## Department of Planning and Environment

**Subject: Request for Advice: Greenwich Hospital Redevelopment - Detailed Design (SSD-13619238)**

**Attachment A:** EHG Comments for Greenwich Hospital Redevelopment - Detailed Design (SSD-13619238)

Appendix E - 1

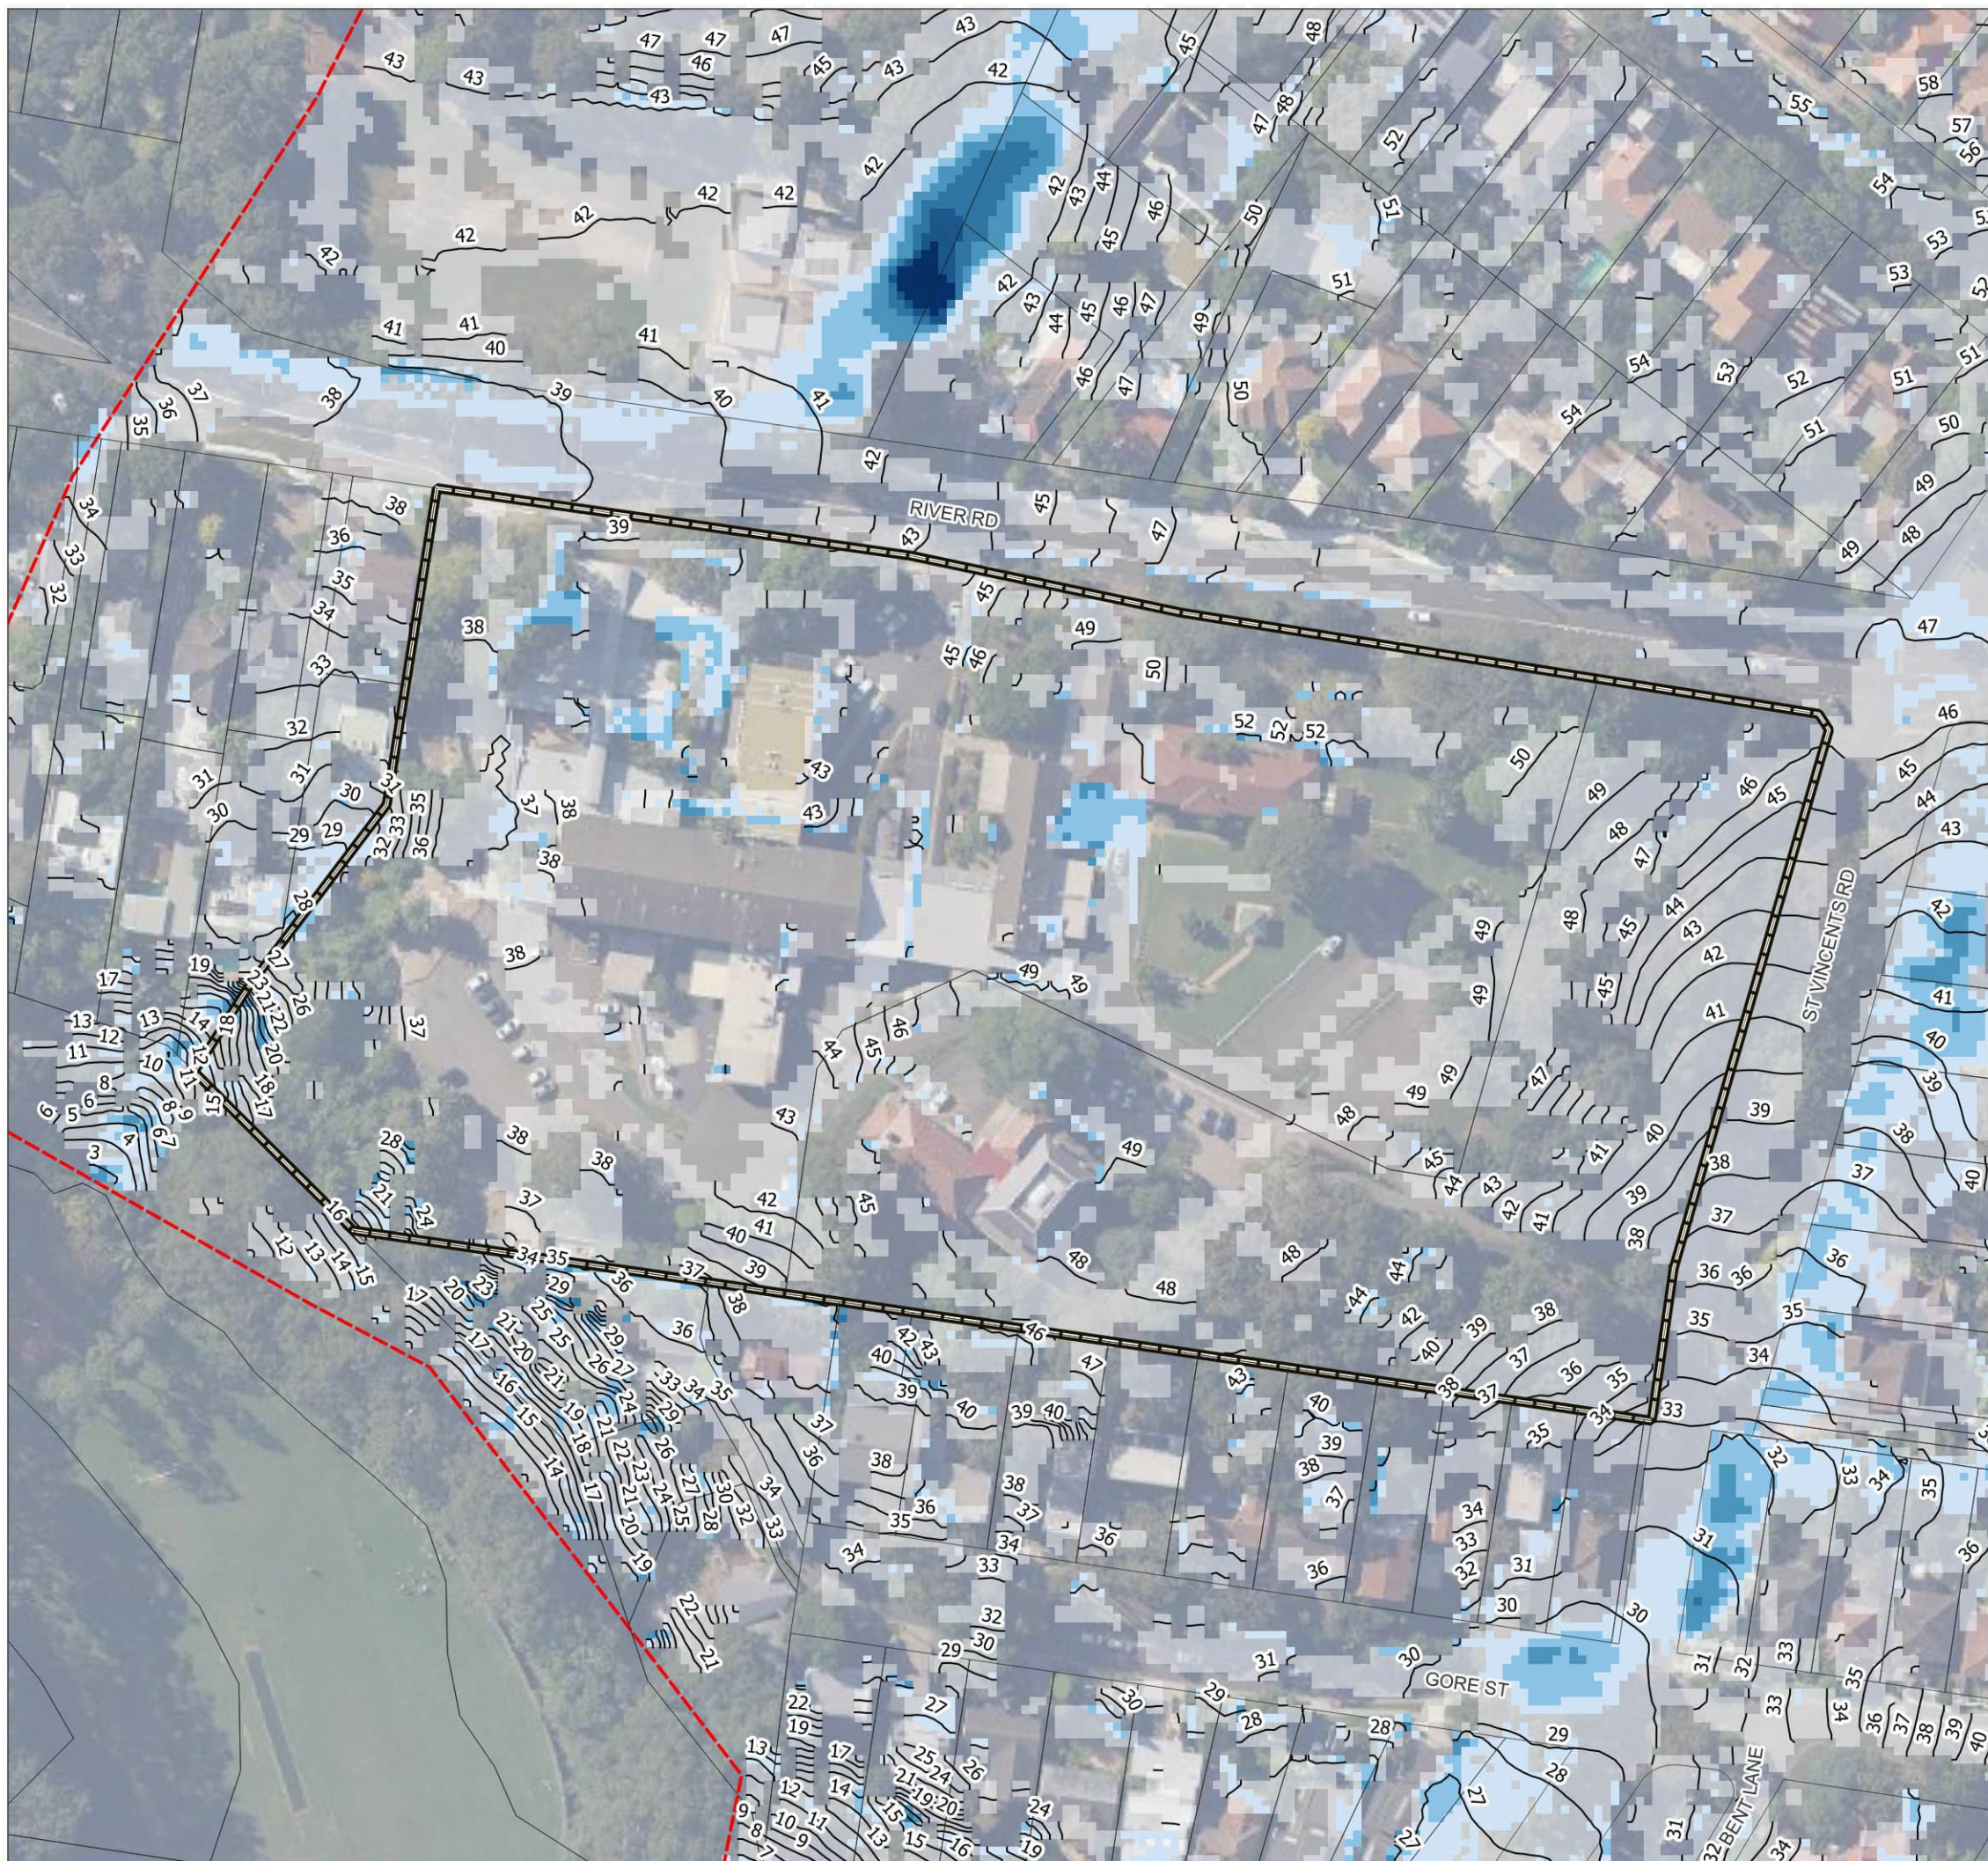
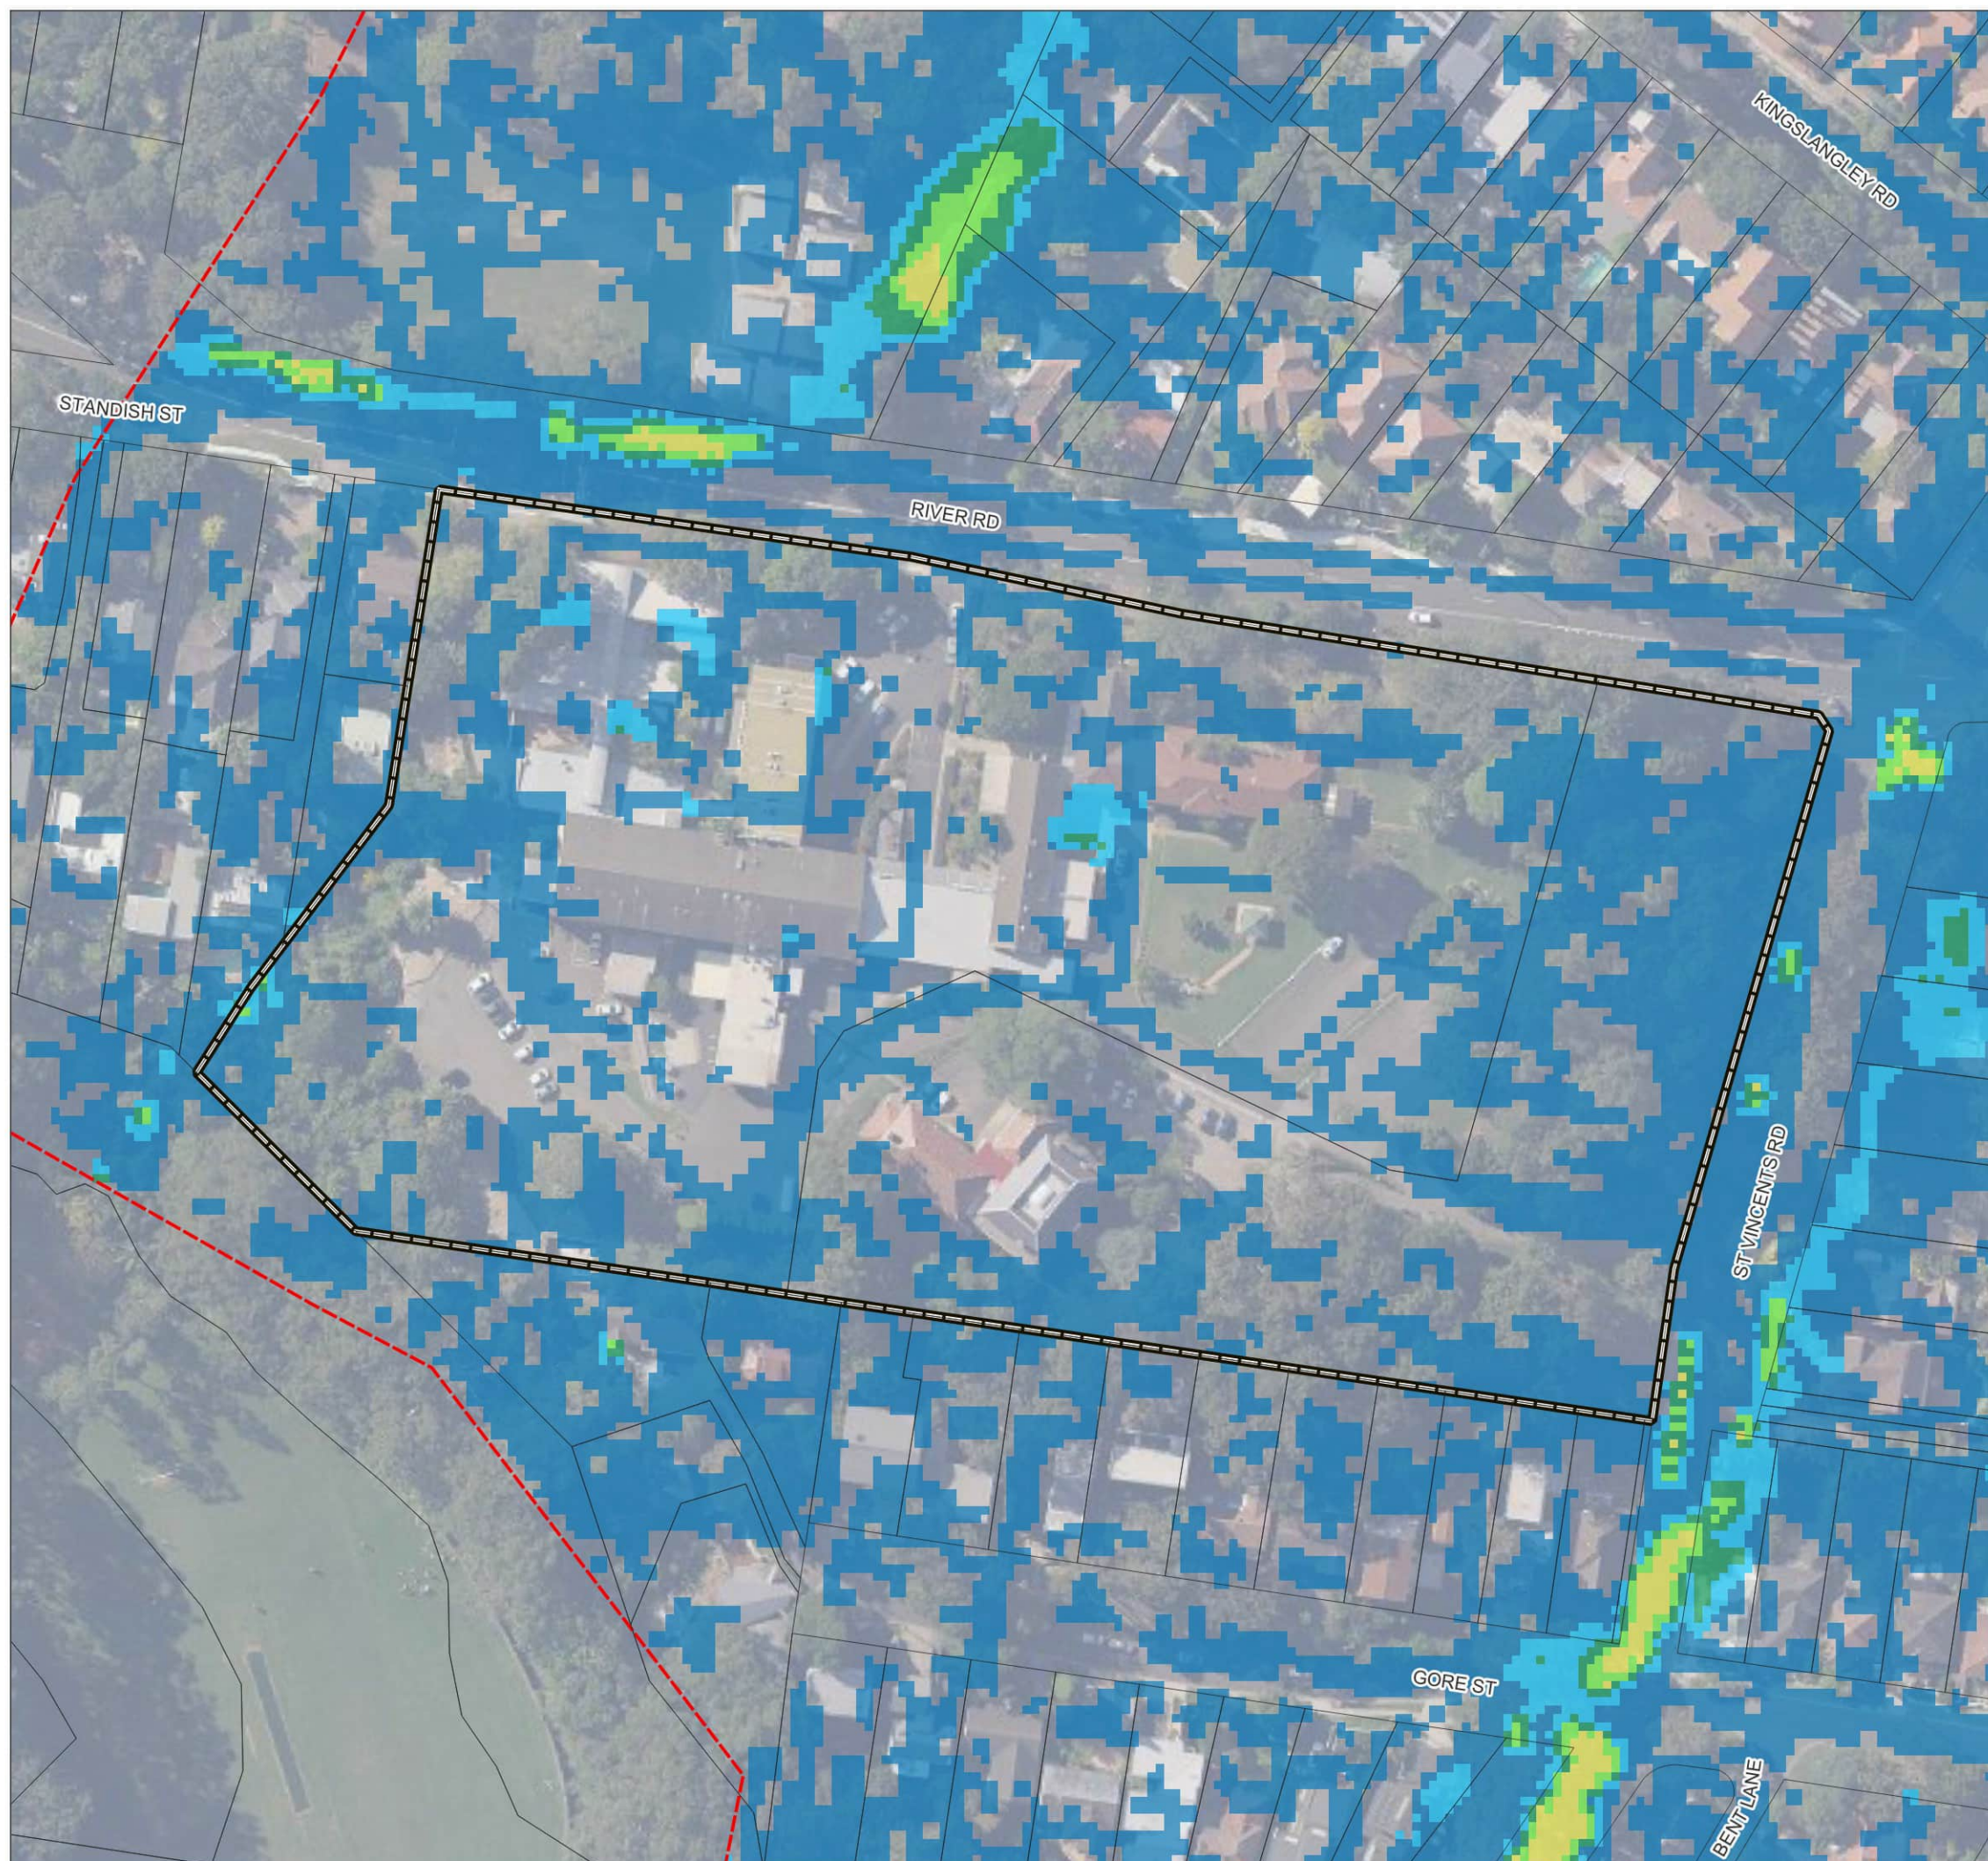
EHG also notes that the flood assessment - Appendix E provided a map of the 1% flood impact assessment, but there is no such map for the probable maximum flood (PMF) event. This mapping should be provided.
